WEST SUSSEX COUNTY COUNCIL CONSULTATION

TO:	Arun District Council FAO: Michael Eastham
FROM:	WSCC - Highways Authority
DATE:	15 November 2021
LOCATION:	L Apache Westergate Street Chichester PO20 3SQ
SUBJECT:	AL/124/21/DOC Approval of details reserved by condition imposed under AL/50/21/PL relating to conditions 3-shchedule of materials & finishes, 6-covered and secure cycle parking spaces, 8-level survey, 9-surface water drainage scheme, 11-connection into the 150mm diameter foul water sewer, 12-decentralised, renewable & low carbon energy supply system & 14-landscaping details.
DATE OF SITE VISIT:	n/a
RECOMMENDATION:	Advice
S106 CONTRIBUTION TOTAL:	n/a

PROPOSED CYCLE STORAGE

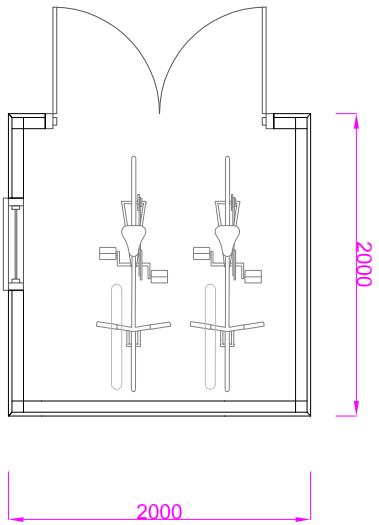
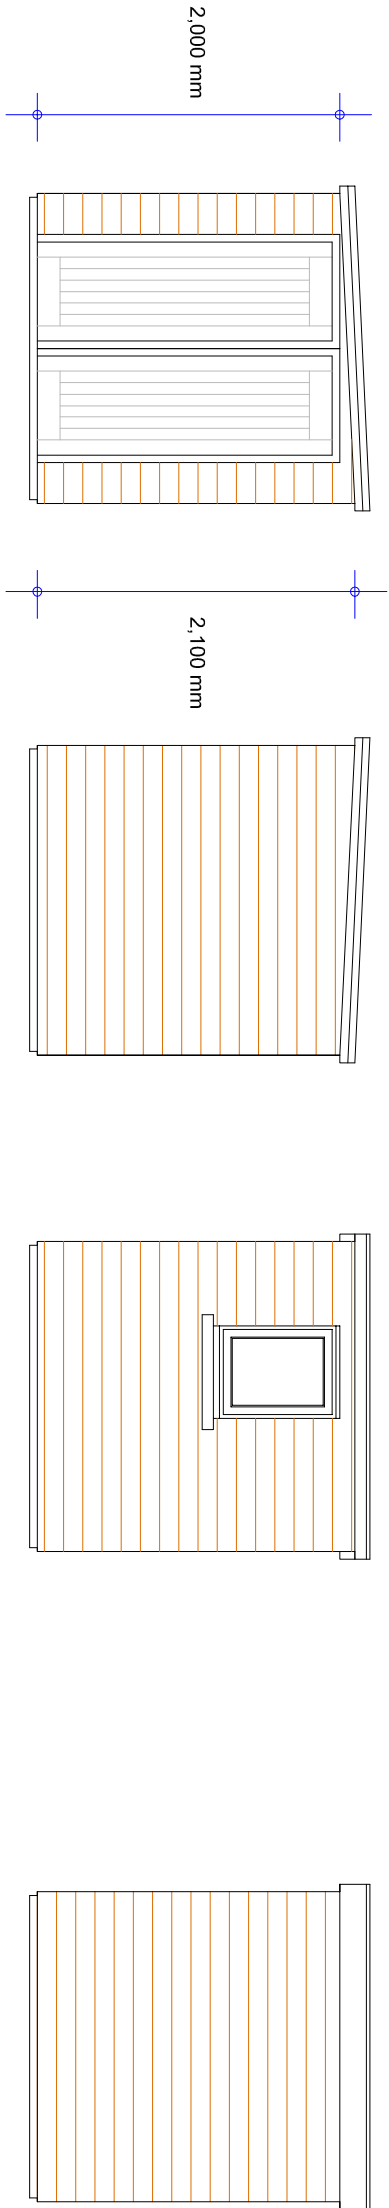
The provided plans demonstrate that a 2 x 2m shed will be provided within each rear garden to provided secure and covered cycle storage for each dwelling, for at least two cycles.

The LHA is satisfied with these details and that condition 6 can be discharged.
